**Re: Application number: 2023/62/93704/E – Detailed Application for 'Erection of 10 dwellings and associated works'**

**Land Northwest of Urban Terrace, Denby Lane, Grange Moor, Huddersfield, WF4 4EB**

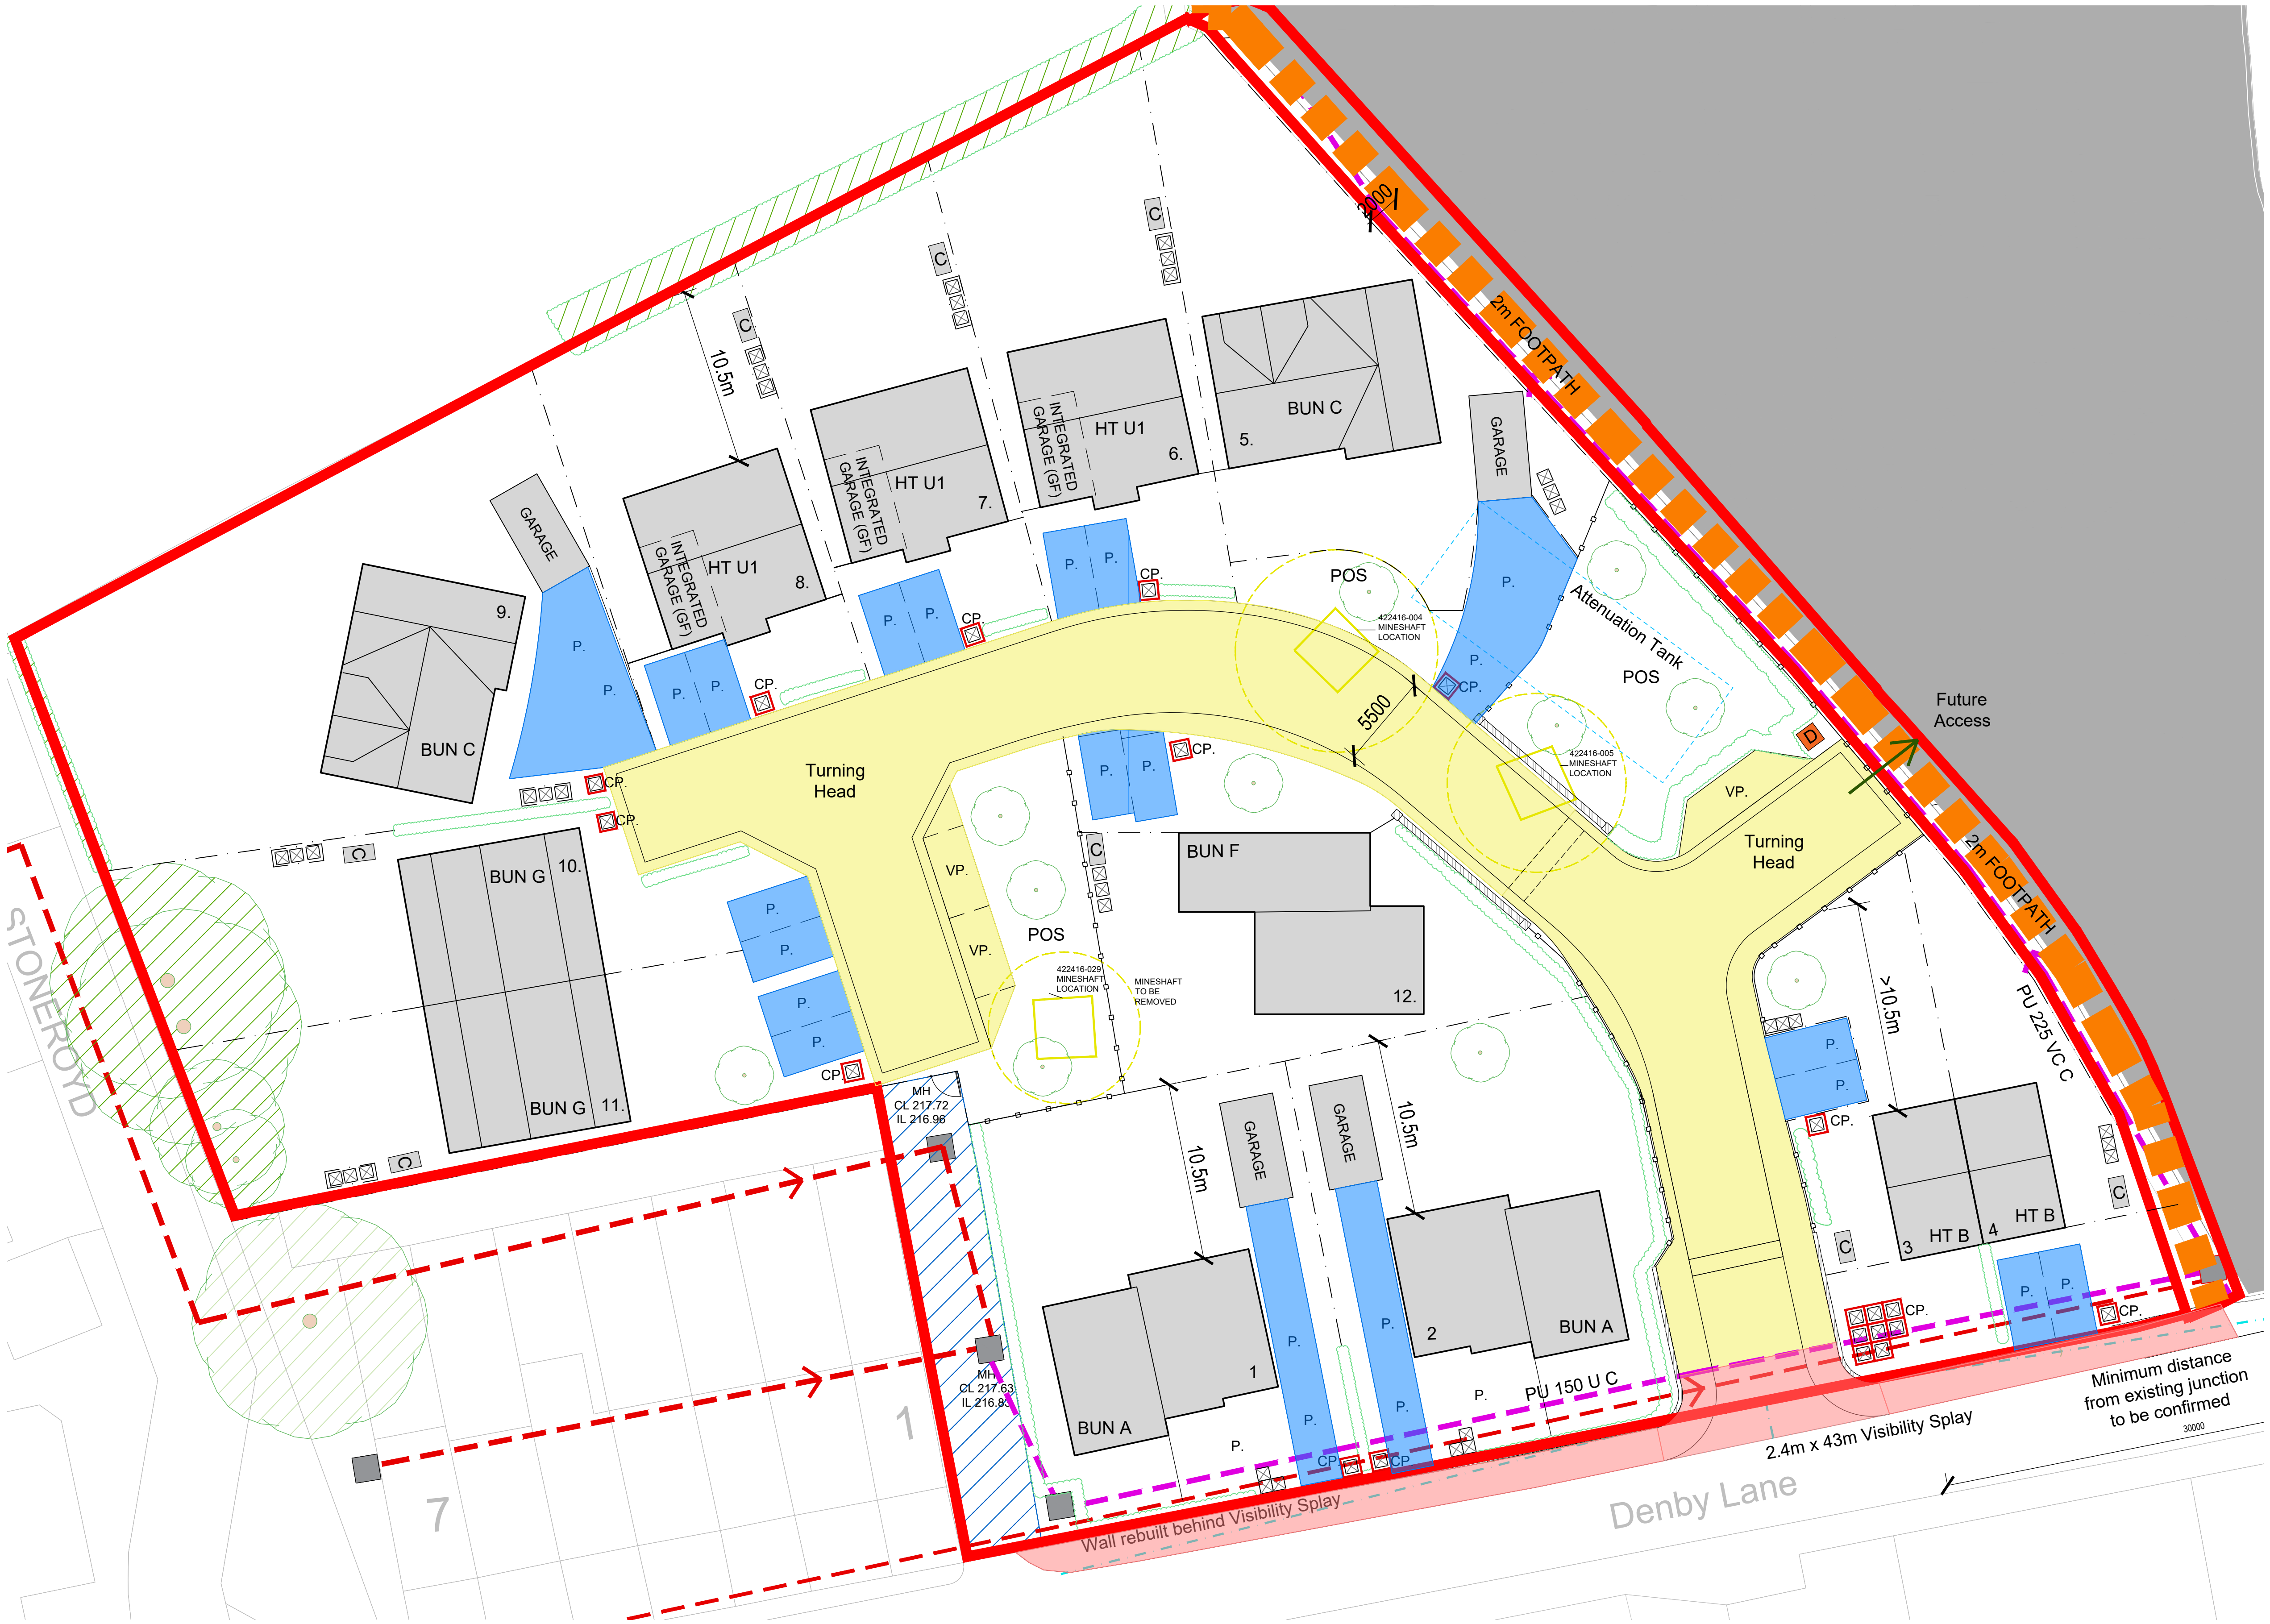
The Layout Plan for Yorkshire Country Properties scheme for 10 bungalows includes a turning head by plot 3 which includes an arrow and the wording '*future access*'. This has not been agreed with me and should not be considered a relevant part of this application.
